**From:** williammharvey [redacted]  
**Sent:** 05 March 2018 11:00  
**To:** Amber Willard  
**Cc:** Liz Hutchings  
**Subject:** Re: FG/115/17/PL

DWG No. 628-05 rev.

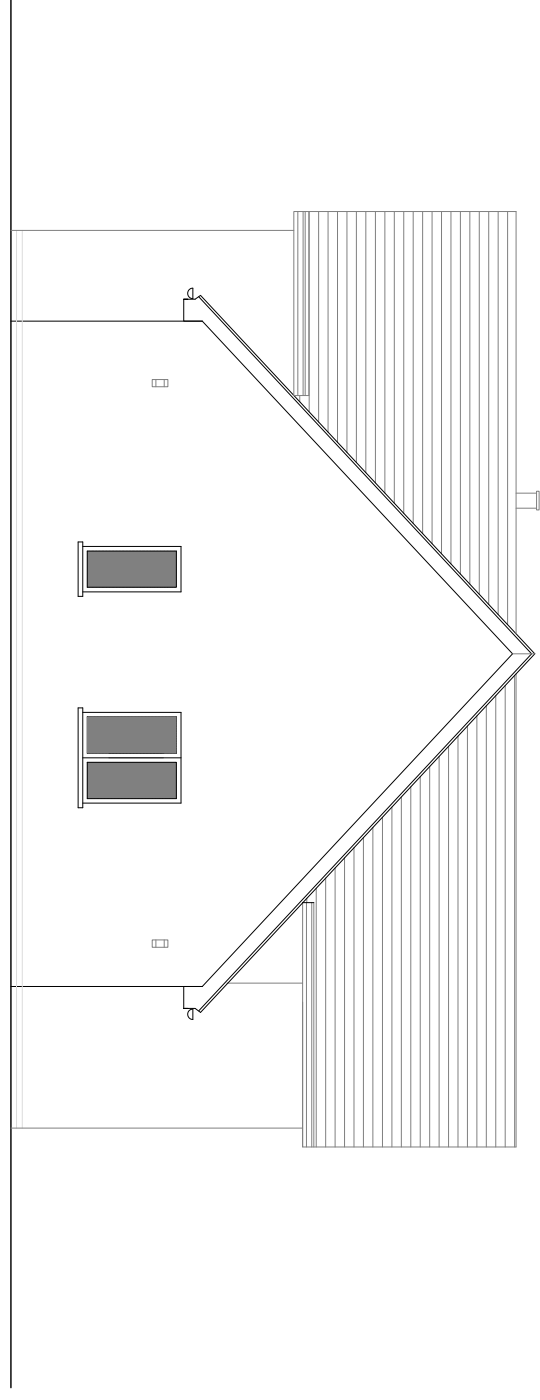
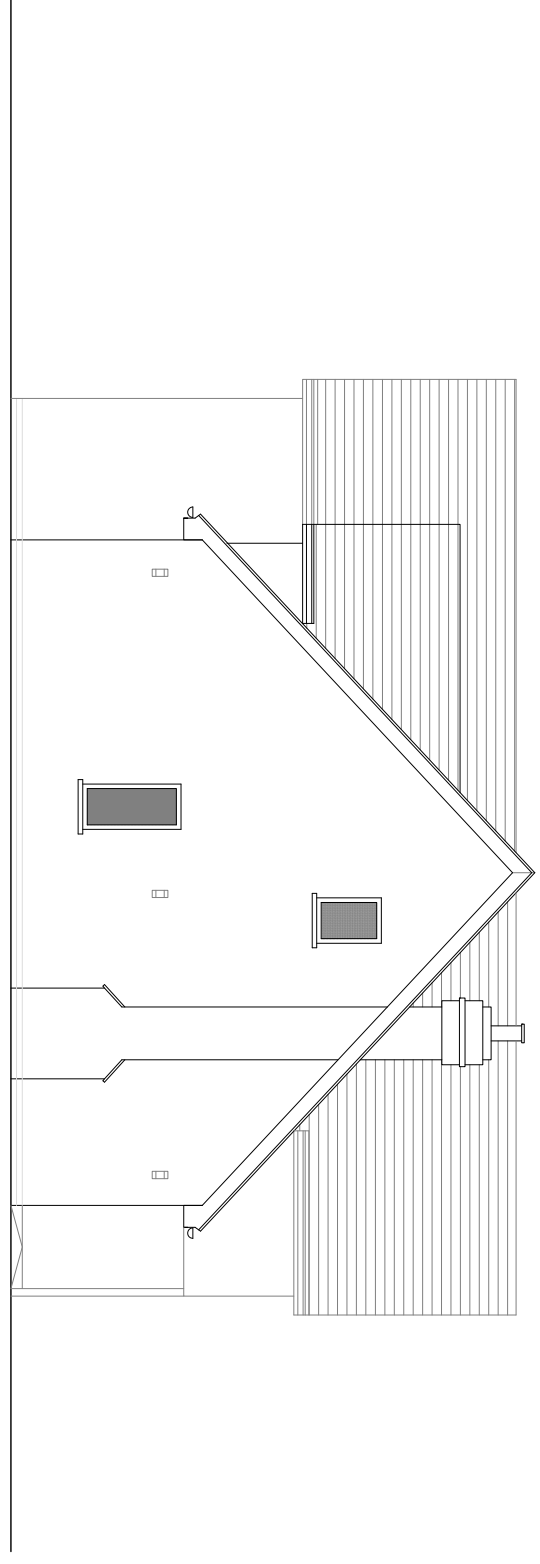
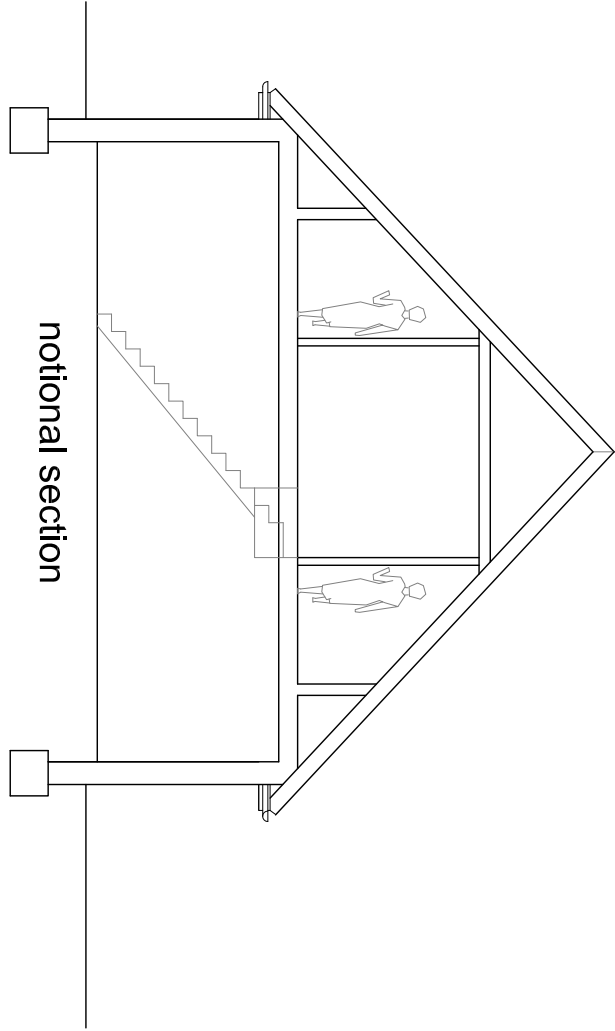
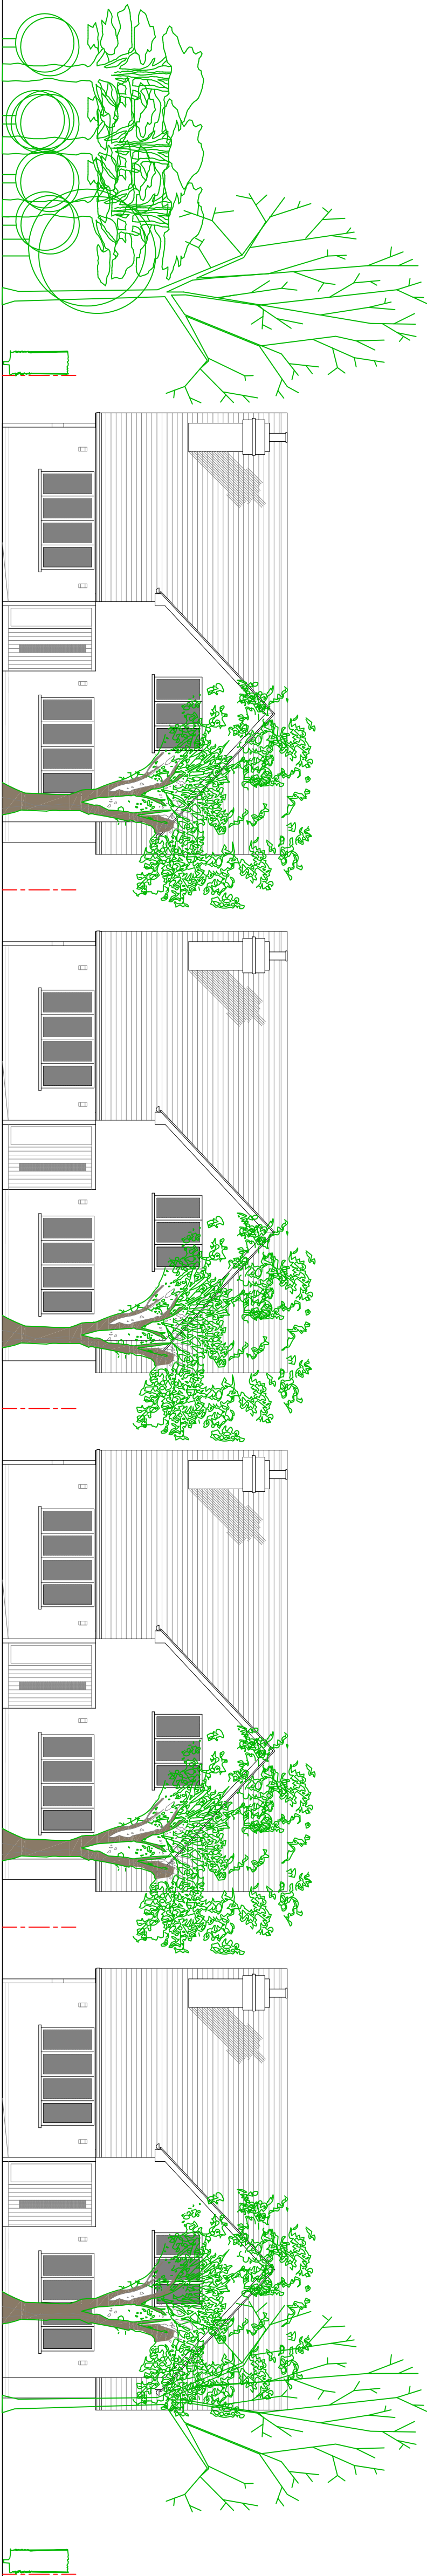
3) the so called bungalows are in fact two storey houses which will result in overlooking of neighbouring properties. Any bungalows approved should be single storey or conditions imposed that any windows/roof lights above ground floor level should be opaque.
